Permit No **970914**

Location of Construction: **# 117 Beverly St (L#148)** Owner: **R.J. Grondin** Phone: _____

Proposed Project Description:
Construct Single Family Dwelling

RE: 117 Beverly Street (lot #148)

Sketch Plan of Property Lot-148 117 Beverly Street, Portland, Maine		
made for Michael J. Maher 117 Beverly Street, Portland, Maine		
JOB# 201403	DATE: 03/19/14	SCALE: 1" = 20'
BOOK# Folder	Stephen J. Martin, PLS Professional Land Surveyor Gorham, Maine 04038	
DISC# autocadd		
FILE# Folder

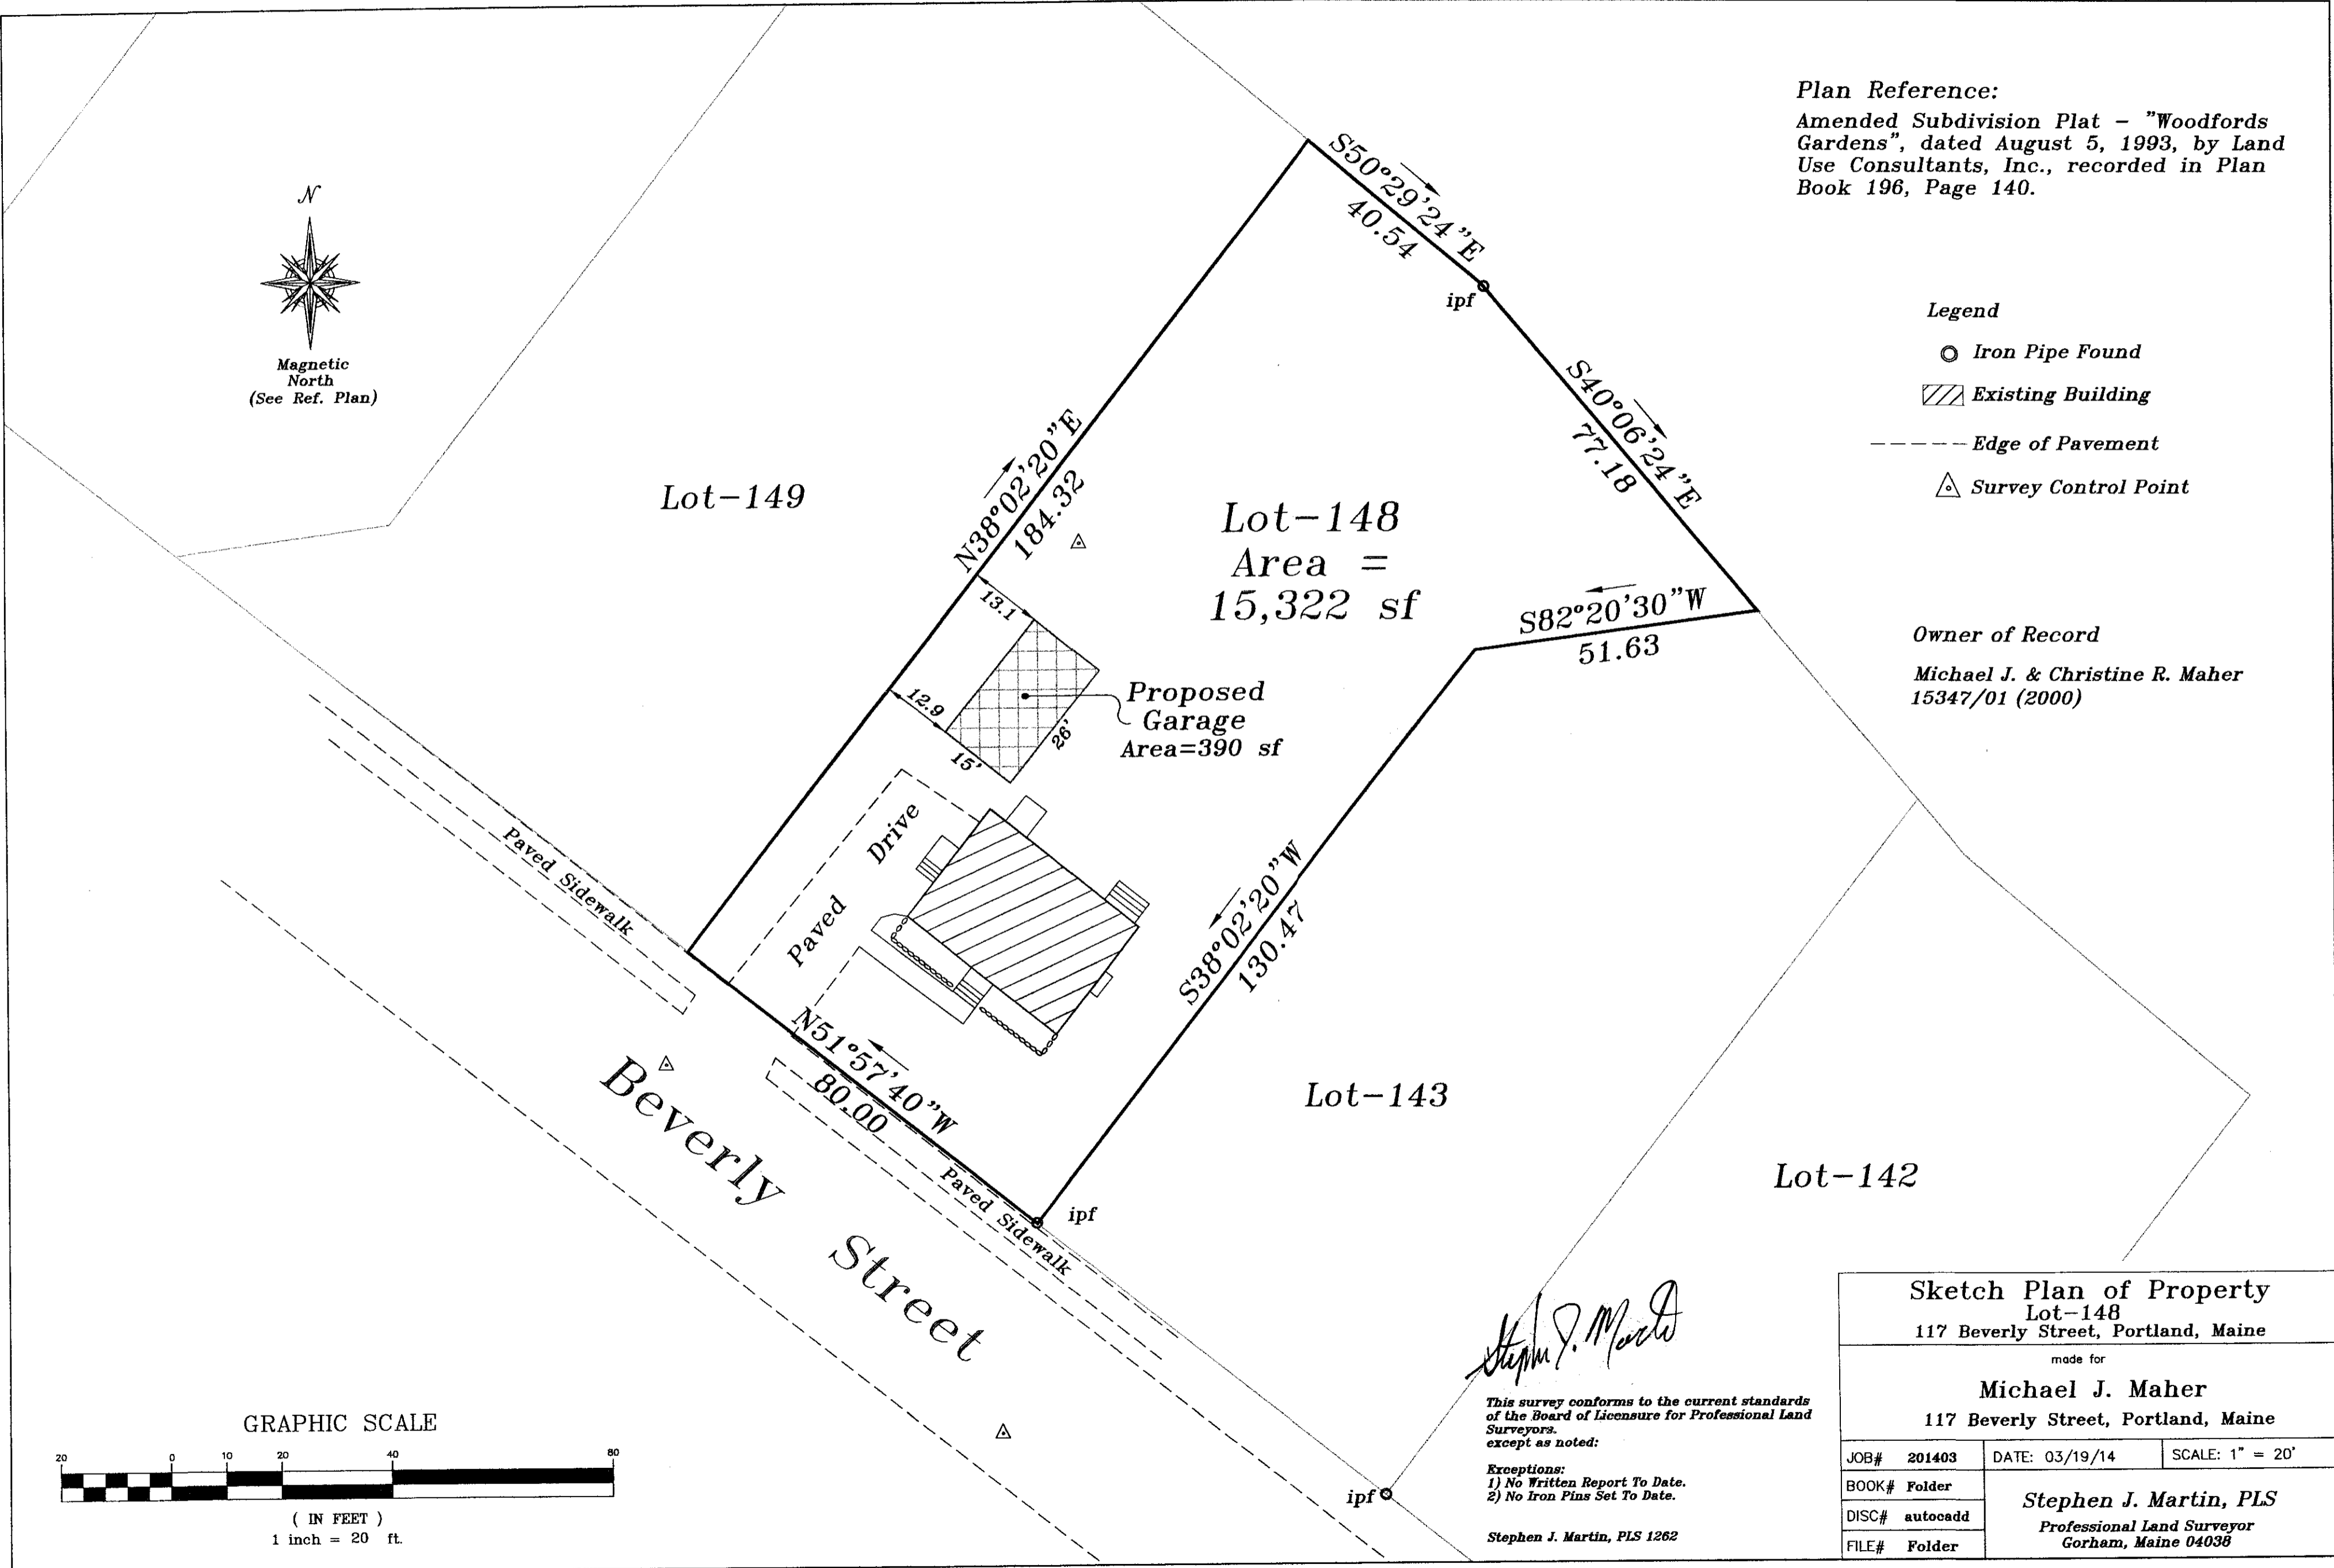
14. SILT FENCE SHALL BE INSTALLED IN THE BACK YARD DOWN GRADIENT OF ALL DISTURBED SOIL.
15. THE LOWEST BLDG OPENING ELEVATION AND THE T.F.W. ELEV. SHALL BE INCREASED BY 6", TO 73.5 AND 75.0 RESPECTIVELY.
16. THE RELOCATION OF THE EXISTING CURB CUT SHALL CONFORM TO CITY OF PORTLAND TECHNICAL STANDARDS.
